DECISION DELEGATED TO DEVELOPMENT MANAGER

Application No: H16-0984-19 **Applicant:** Seagate Homes
Proposal: Residential development - comprising 40 dwellings - outline approved H16-0668-16
Location: Millfield Nursery Spalding Common Spalding
Terminal Date: 28th February 2020

DRAWING Landscaping - Phase 1

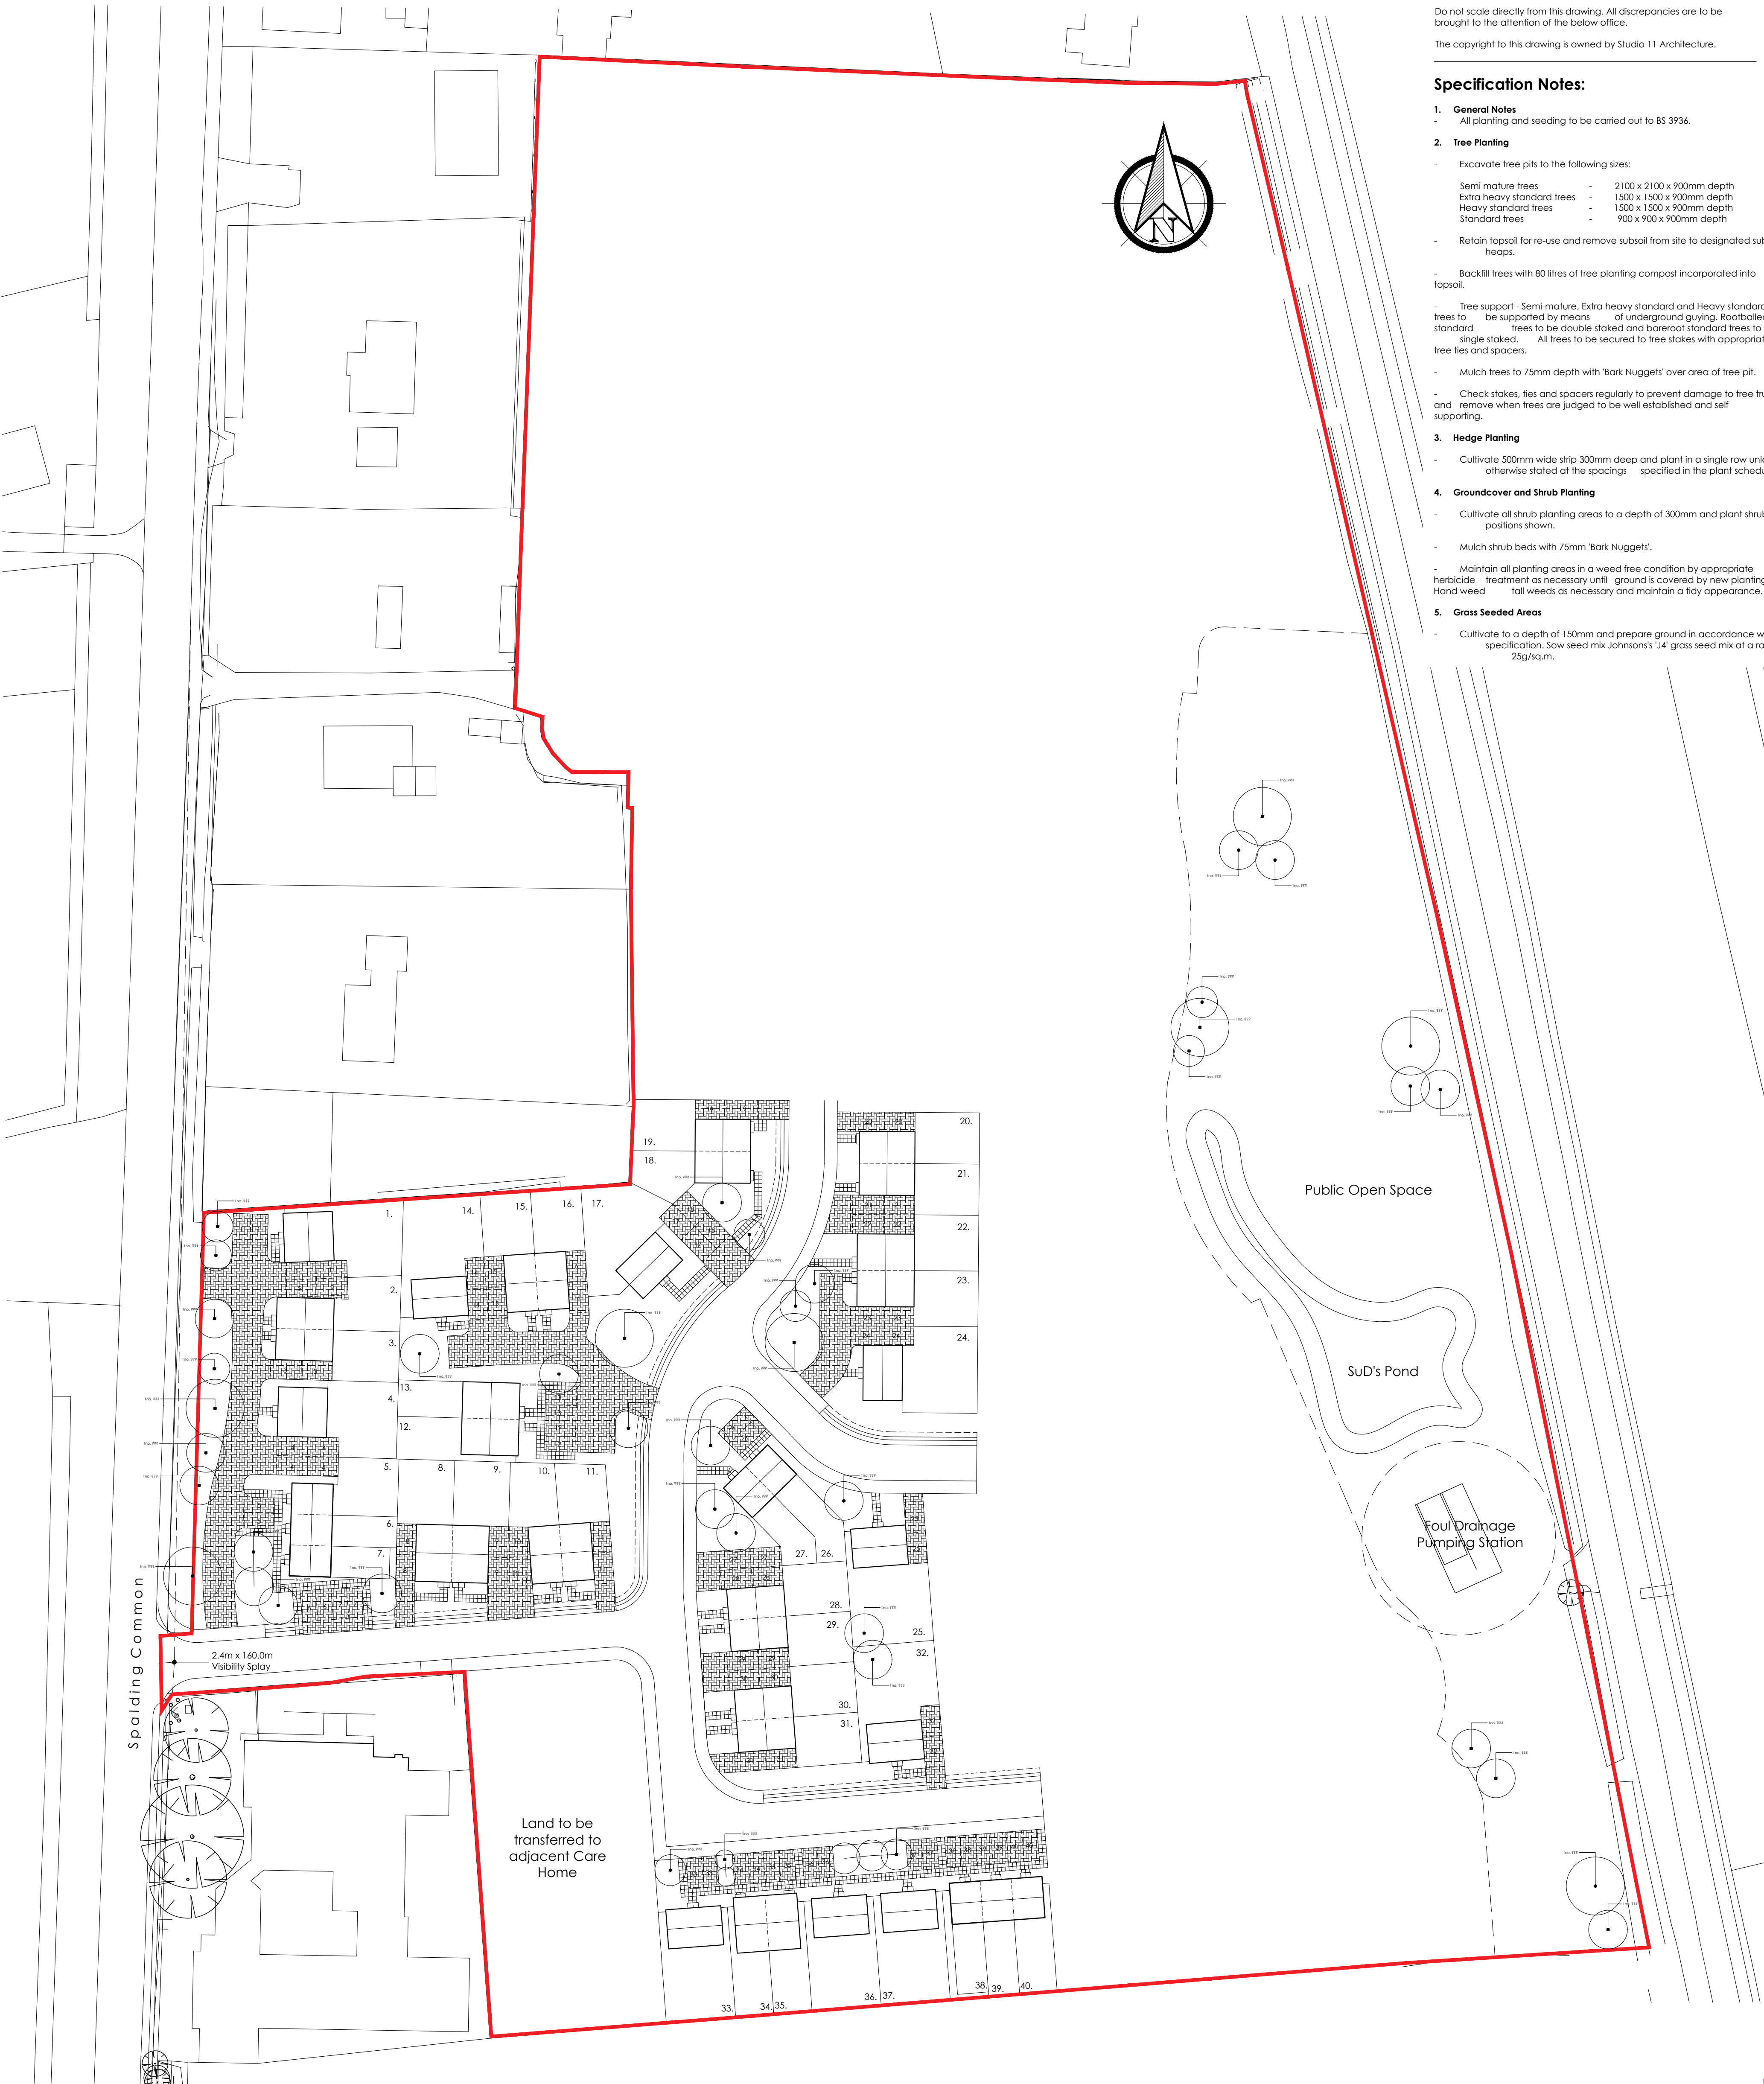
Comment on planting and landscaping on western boundary.

Since submission the landscaping proposal has removed planting from the western (Spalding Common) boundary to enable access for the IDB. This is a retrograde step however it is a requirement that access is kept to the IDB interests. At this point the dwellings are set back and accessed from a private drive, so an element of visual openness will be kept. A knee rail fence is proposed to discourage parking on the green edge.

Officer note - The plans have been amended in accordance with the IDB requirements. The IDB have been reconsulted but no response has been received.
